Preliminary Acceptance Punchlist
El Paso County – Department of Public Works - Stormwater Section

Project Name:	Bent Grass Residential F2
EDARP Filing Number(s):	SF1914, CON2022
ESQCP Number:	ESQ228
Attendees:	DPW SW: Dylan Finley, Ben Jones DPW Development Services: Spencer Pirzadeh, Brad Walters Developer: George Hart, Erin Ganaway
Date of Walk-Thru:	09/13/2023
Walk-Thru Number:	1

POND (NORTH) PLAN VIEW
SCALE: 1"=20'

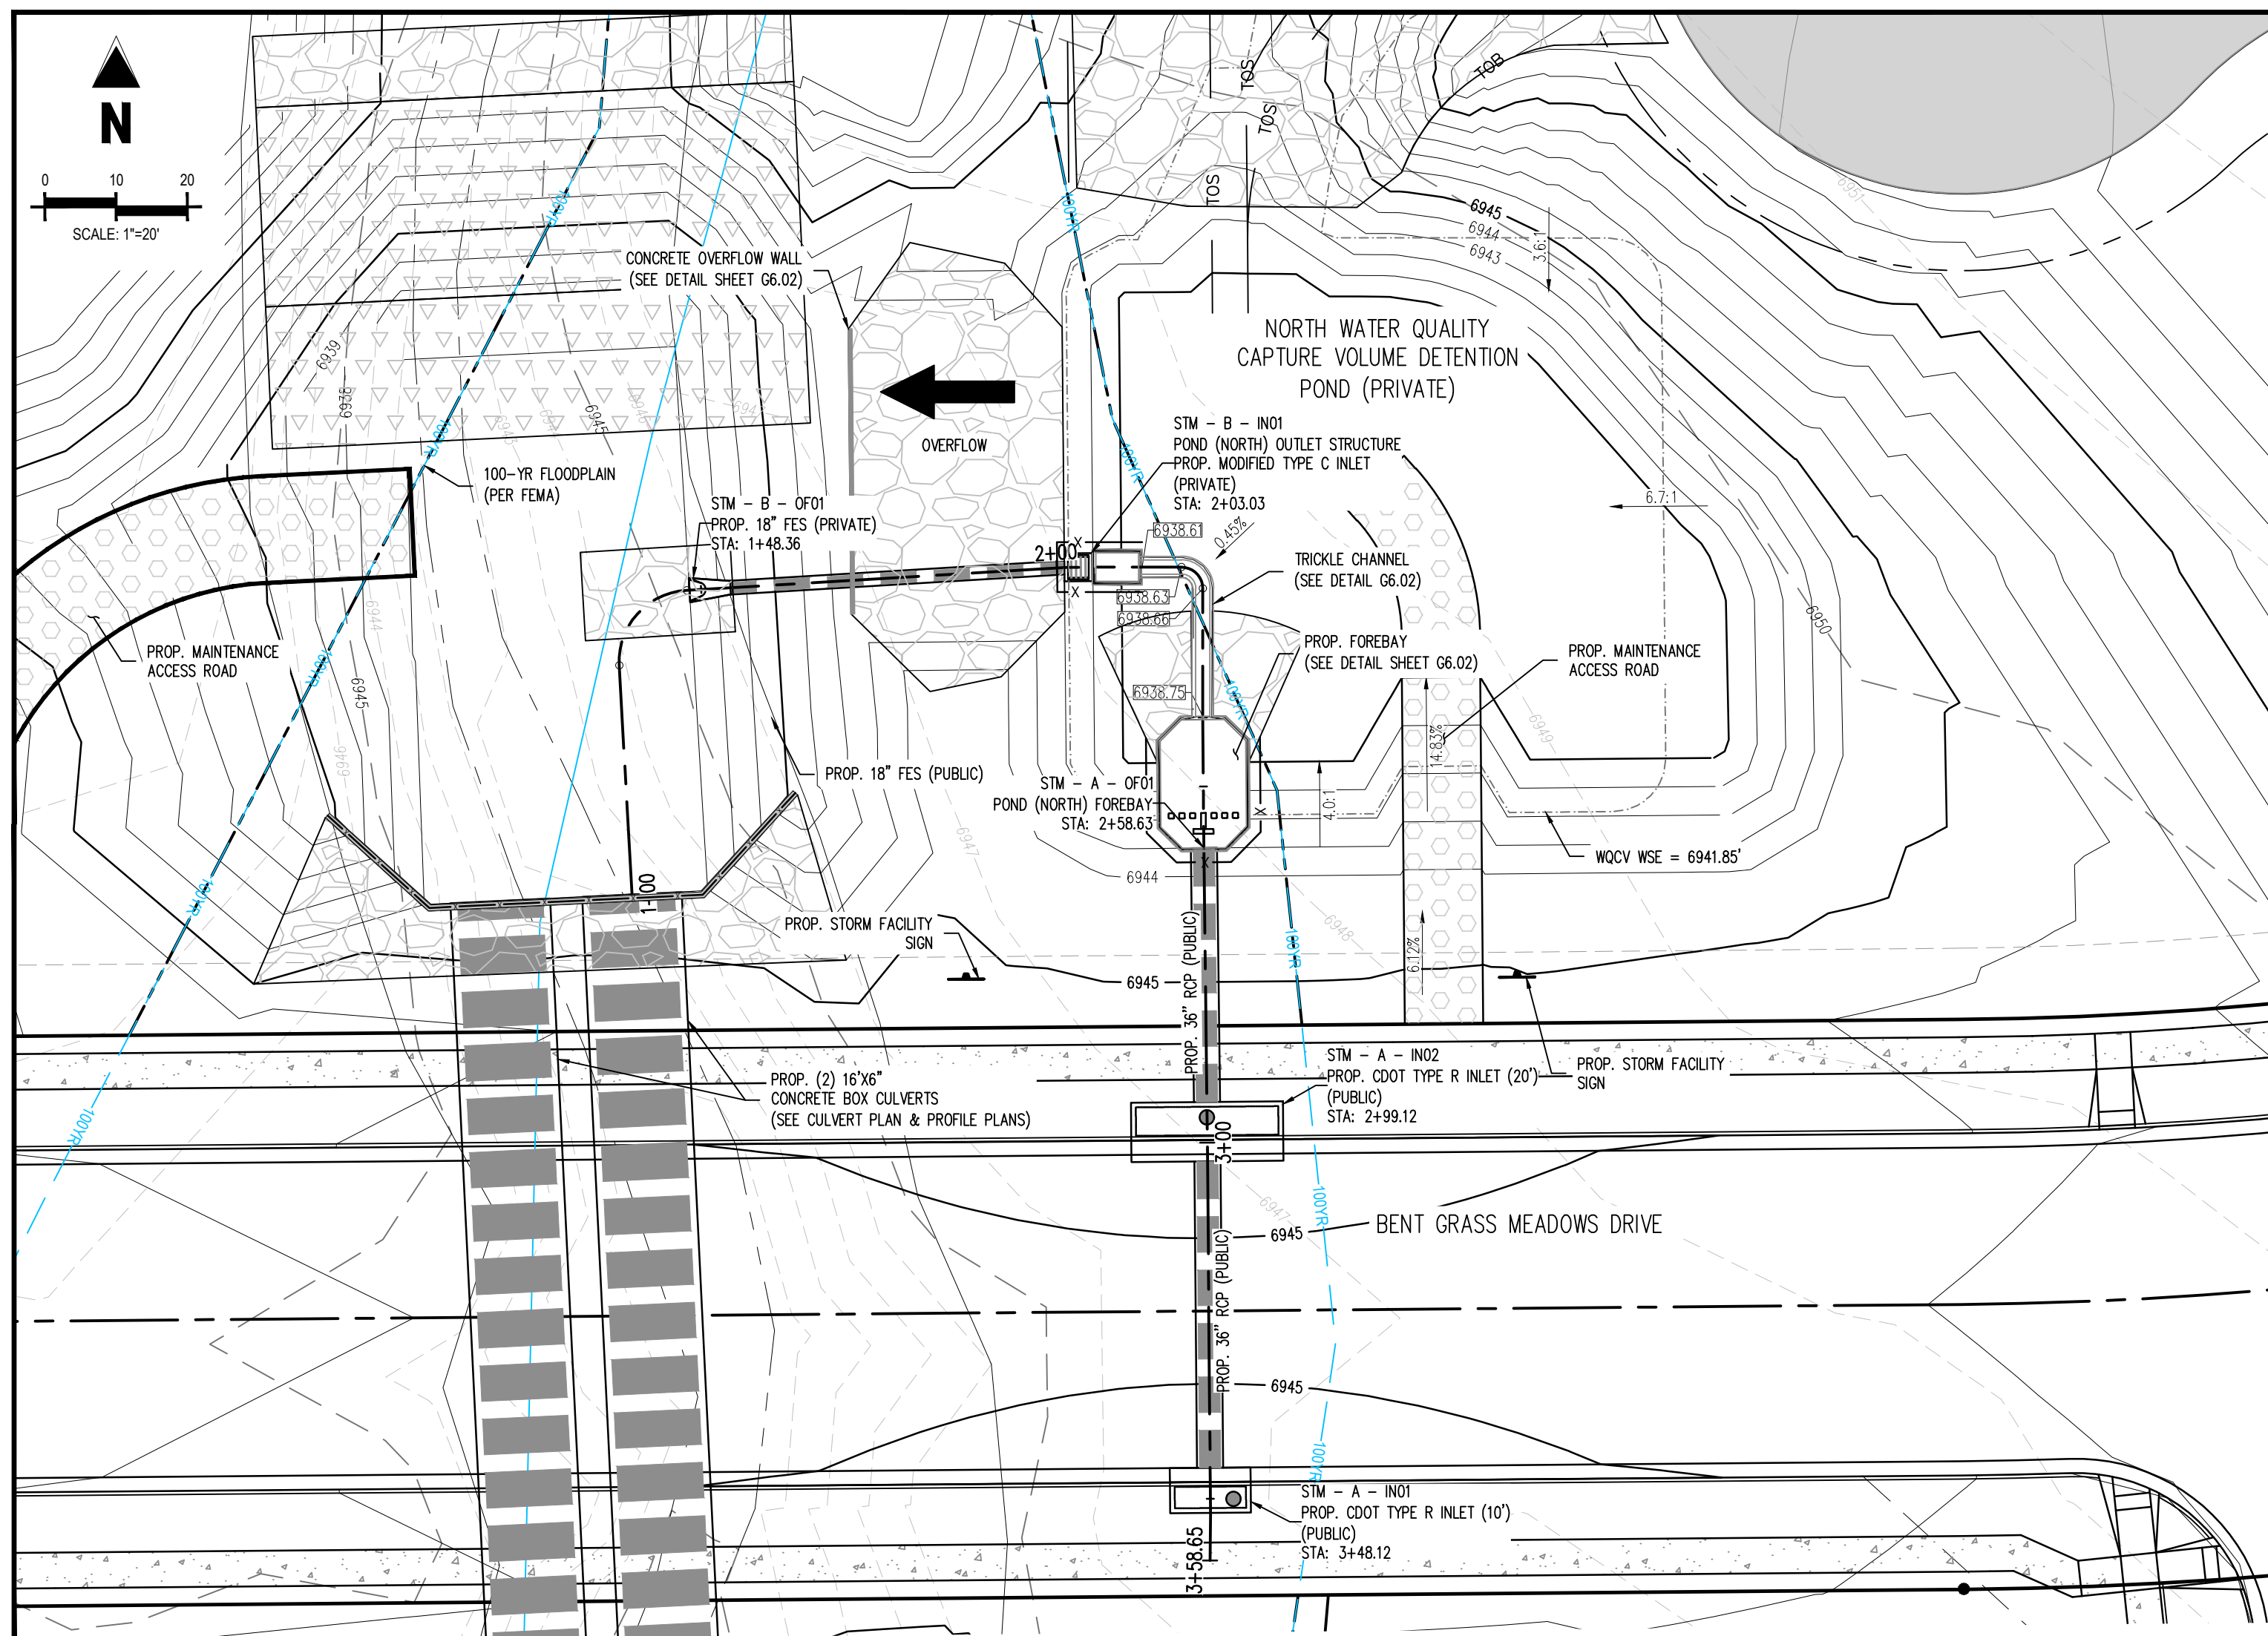
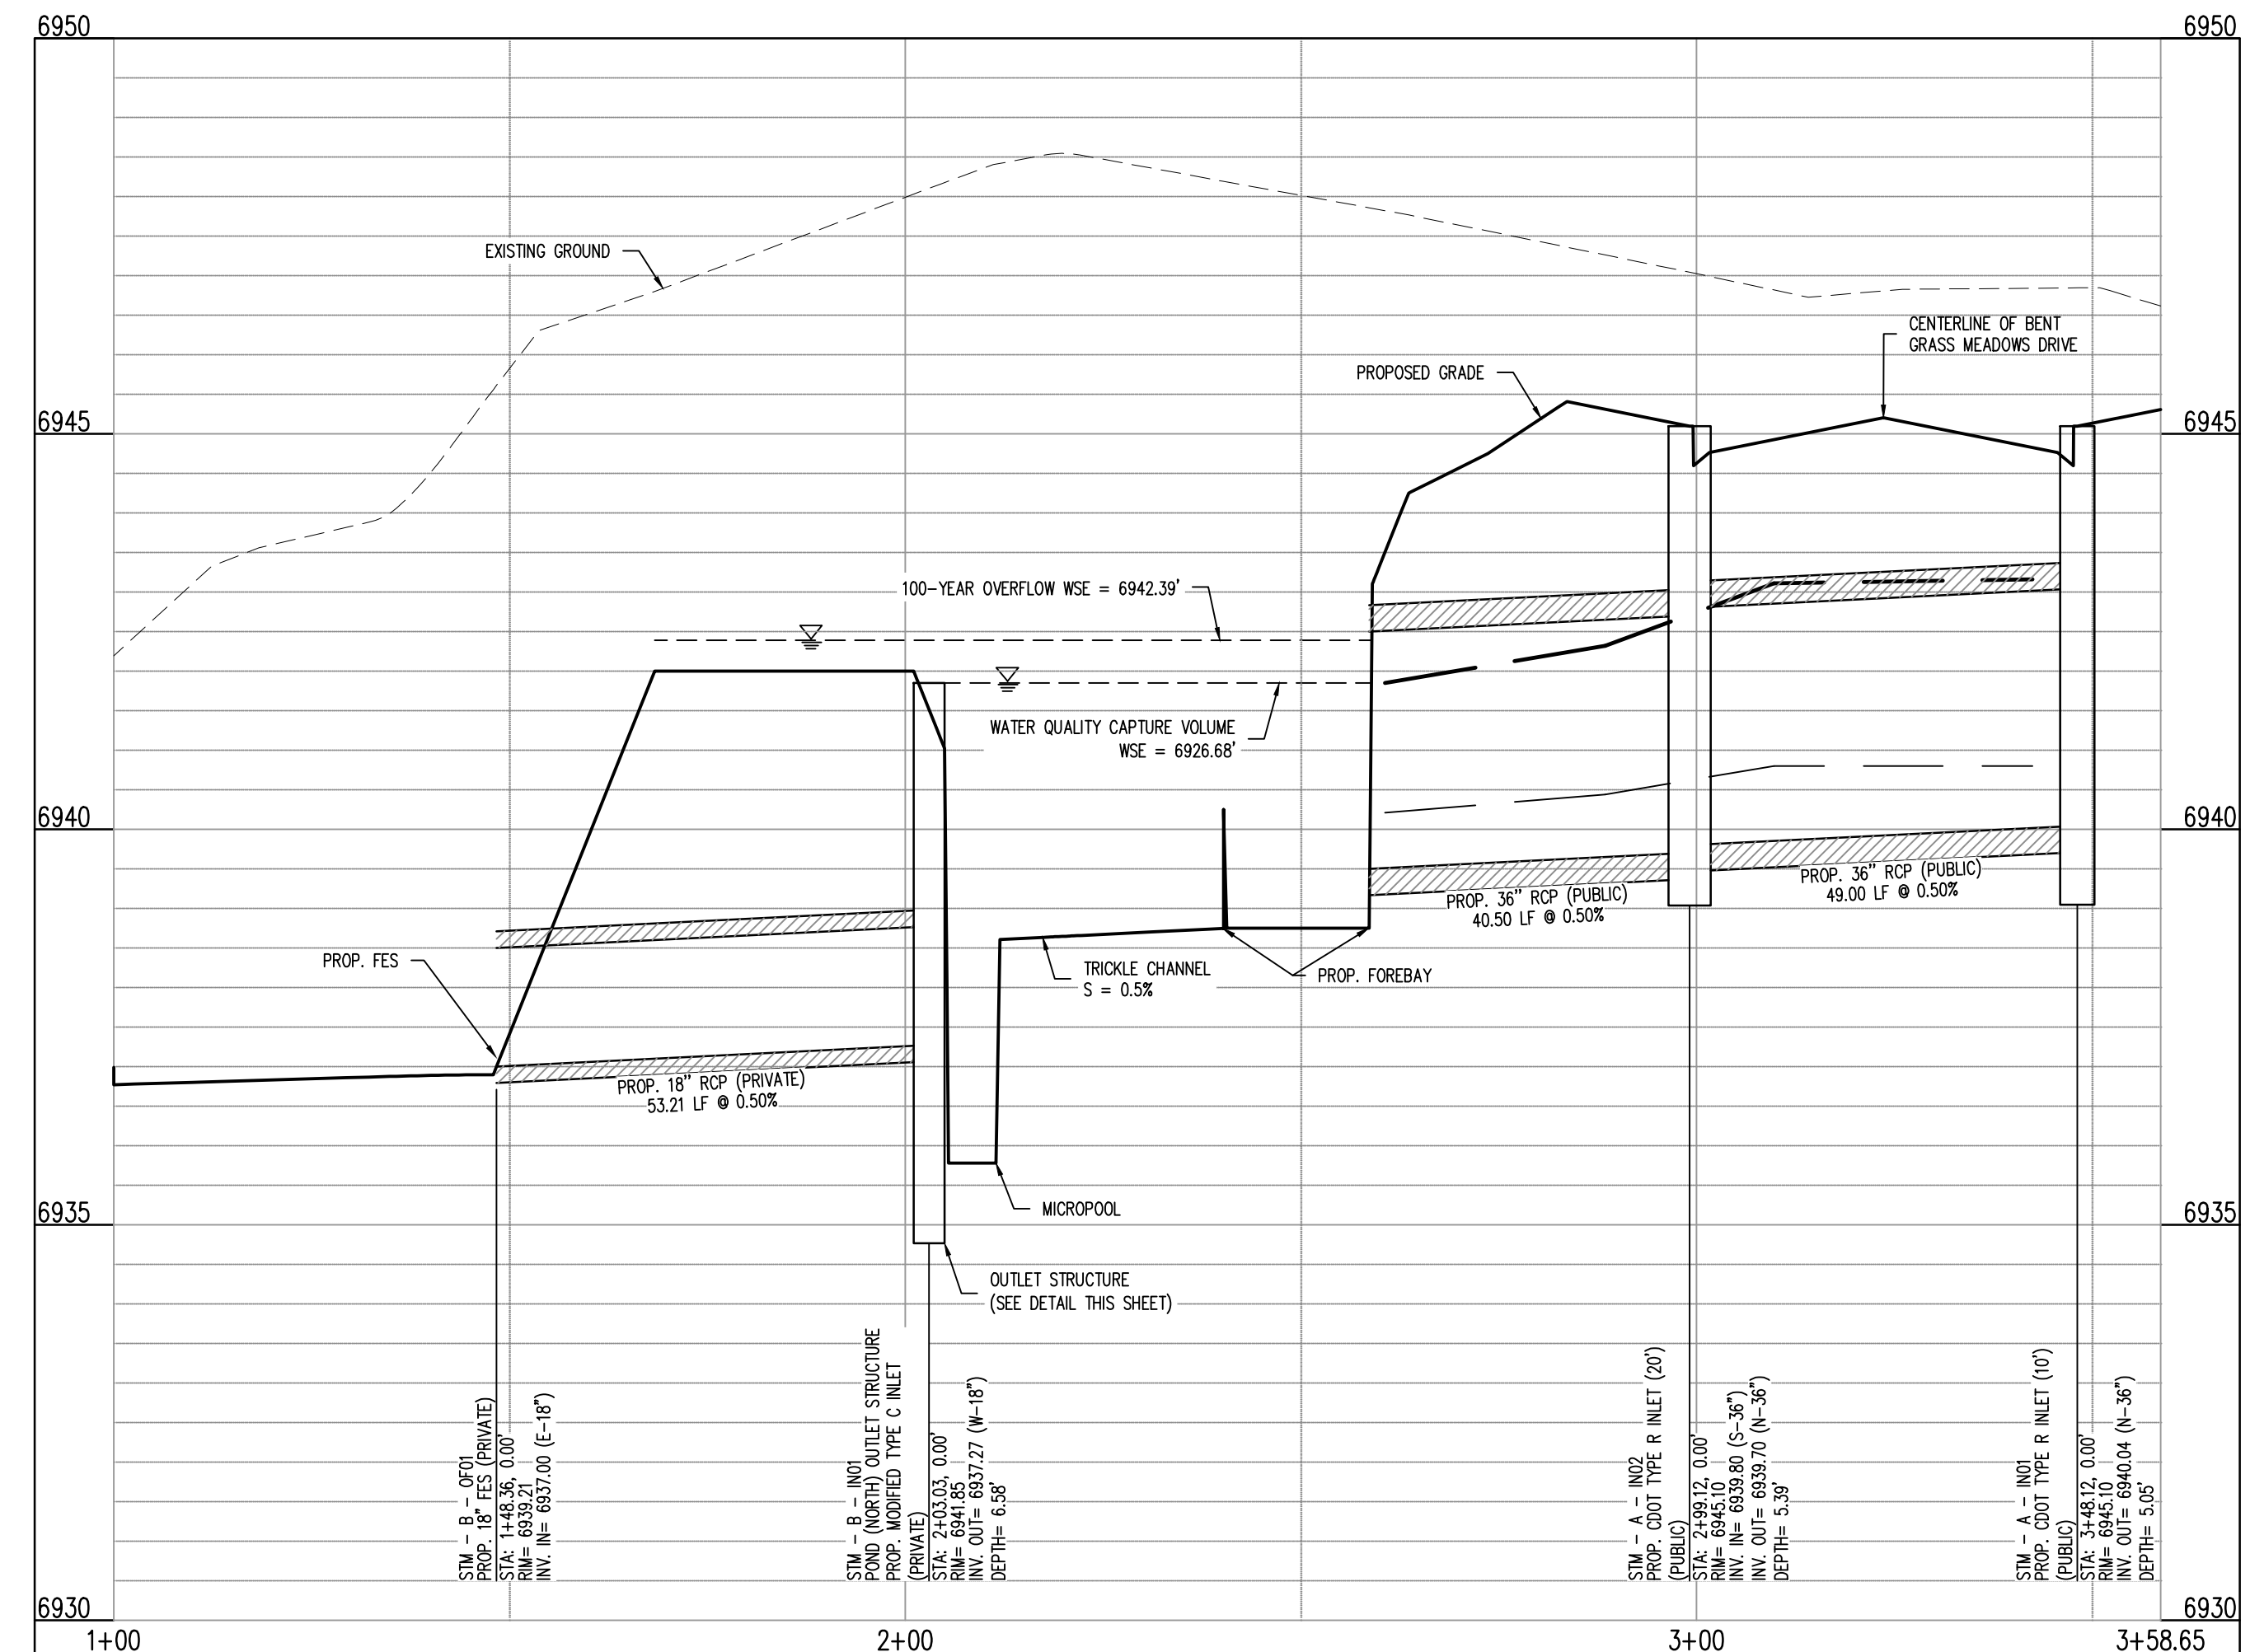
- Findings listed on 6/23/22 punchlist and still not completed:
 - Missing outlet protection. (Type L soil riprap page G5.02)
 - As of 9/13/23, all pond components and pond bottom have lots of sediment throughout that needs to be removed, including all riprap. Unable to complete inspection of the previous findings listed below because of amount of sediment covering pond. The PA inspection will be completed once sediment is removed. And the items below will be re-inspected.

- Remove sediment and debris throughout pond.
 - Grade pond to top of trickle channel curb.
 - Grade pond bottom to min 3% slope towards trickle channel.

- Install restrictor plate on outlet pipe per plan and UD-Detention spreadsheet.
 - Confirm gasket at orifice plate.
- Repair erosion on northern embankment of pond.

- Repair erosion around south side of spillway cutoff wall.
- The grade of the north side of the spillway has been raised due to an adjacent temporary access road. This appears to be causing the aforementioned erosion. Regrade north side of spillway per plan.
